**Re: 23-45 Tattersall Road, Kings Park – Fire Hydrant Assessment Report Close Out**

# FIRE HYDRANT ASSESSMENT REPORT

## **SELL & PARKER, BLACKTOWN**

Date: 15 June 2020

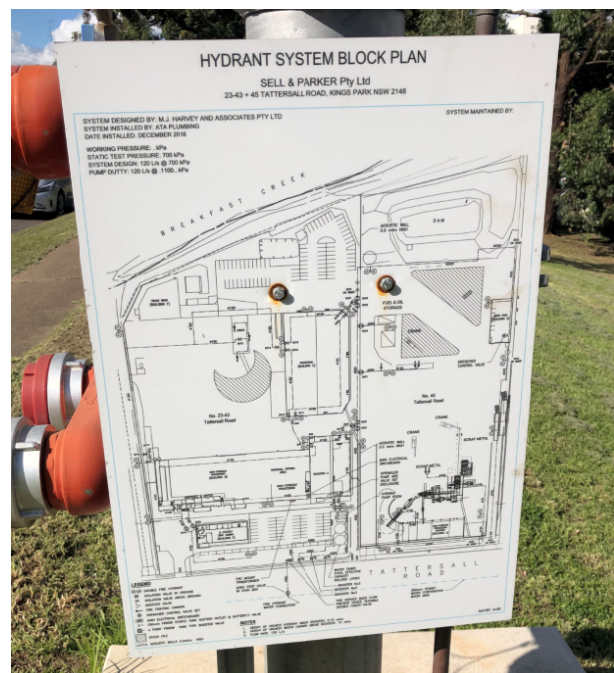
It was observed that the existing booster valves are not secure or locked in the open position.

1. The existing booster assembly is non-compliant due to the booster valves not being secure or locked in the open position.
2. The booster inlet pipes do not have an isolation valves downstream of the booster inlets. Booster inlet pipes are required to have an isolation valve if the head at the inlets can be greater than 50kPa due to the pumps running.
3. No signage to identify the booster assemblies in accordance with Clause 7.10 of AS2419.1 – 2005.
4. FH Block plan has incomplete and incorrect information in accordance with Clause 7.11 of AS2419.1 – 2005
5. The fire brigade hardstand was observed to be non-compliant at the time of inspection due the fire brigade booster assembly being obstructed by parked cars.
6. Boost and Test Pressure signage is not provided for the boosters.

1. The booster valves shall be secured in the open position with a padlock openable by the fire brigade 003 key.
2. Isolation valves shall be provided downstream of the booster inlets.
3. Provide separate stands for signage of

the 'FH Booster' and must be adjacent the suction and inlet points to avoid confusion with the adjacent sprinkler booster.

Location of FH24

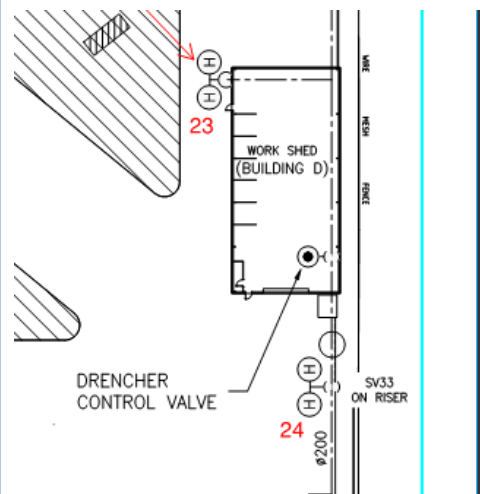
It was observed during the inspection that FH24 was obstructed by existing sheds and did not have a cover.

1. The existing fire hydrant system is not compliant due to the fire hydrant accessibility being obstructed by the existing sheds.
2. The existing fire hydrant system is non-compliant due to the fire hydrant outlet without having a protective cap to block debris and other contaminants from entering the pipes.

1. The fire hydrant shall be relocated to an accessible location in front of the sheds.
2. The fire hydrant shall be kept covered when not in operation. Caps shall be provided to missing fire hydrants.

Risers entering Building B from SV1 and SV2 without bollard protection

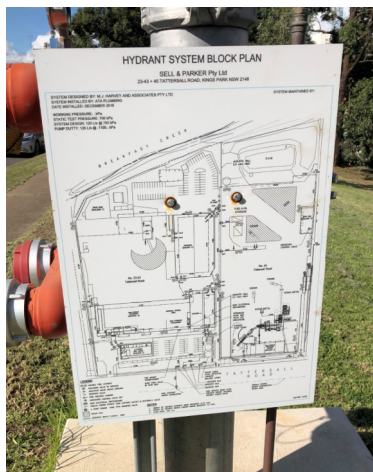
The existing fire hydrant system has pipework and in areas with moving vehicles, without protection of damage from the vehicles.

The existing fire hydrant system is non compliant because AS2419.1 requires fire hydrants and pipework to be located so that the fire hydrant system is protected from possible mechanical damage by vehicles. The following pipes are required to, but did not have any protection from physical damage:

- Risers entering Building B from SV19 and SV20
- Risers entering Building B from SV1 and

The risers serving Building B from shall be provided with bollard protection from moving vehicles.
